Southampton to London Pipeline Project

DCO Application Errata

Application Document: 8.64

January 2020

Figure 3.1: Layout of Scheme (14 Sheets)

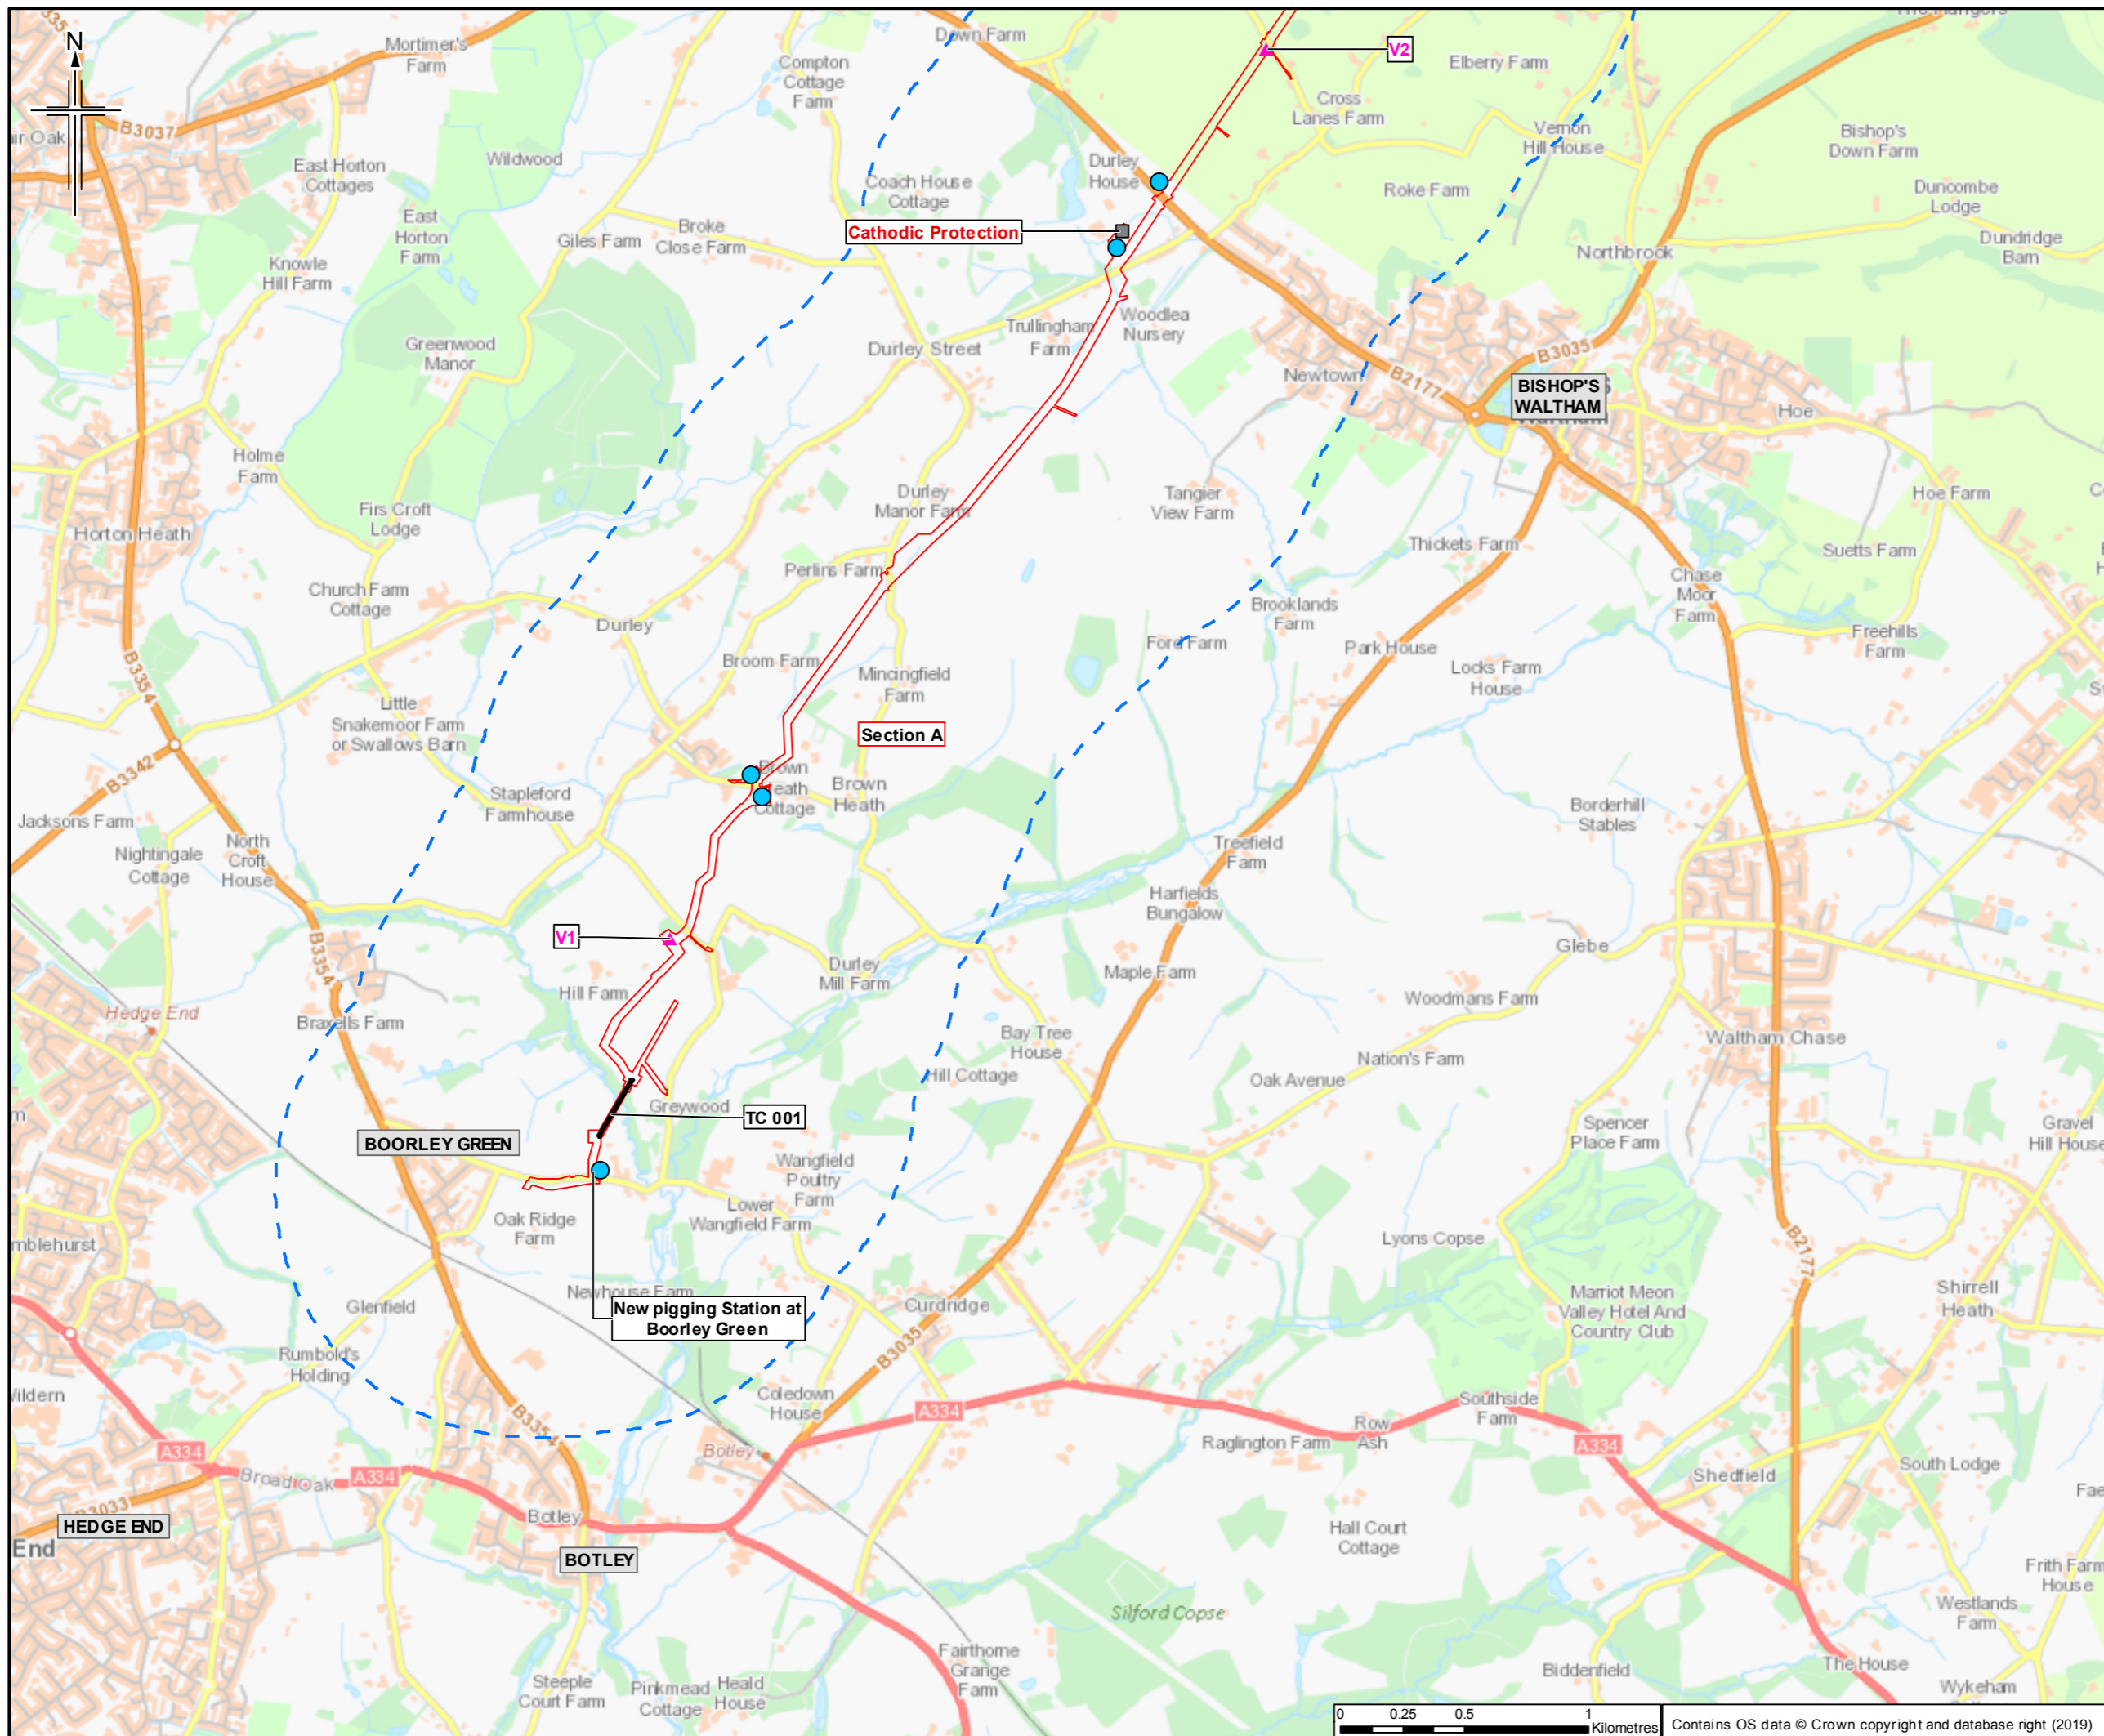
| Section and Paragraph Reference | Nature of Erratum and Explanation |
|---------------------------------------------------------------------------------------------------------------------------|---------------------------------------------------------------------------------------------------------------------------------------------------------------------------------------------------------------------------------------------------------------------------------------------------------------------------------------------------------------------------------------------------------------------------------------------------------------------------------------------------------------------------------------------------------------------------------------------------------------------------------|
| <p>Figures Chapter 3 Project Description (Application Document APP-059) Figure 3.1</p> | <p>The label for the 'new pigging station at Boorley Green' in Figure 3.1 is in the wrong place, it should be shown at grid reference SU51774 15371.</p> |
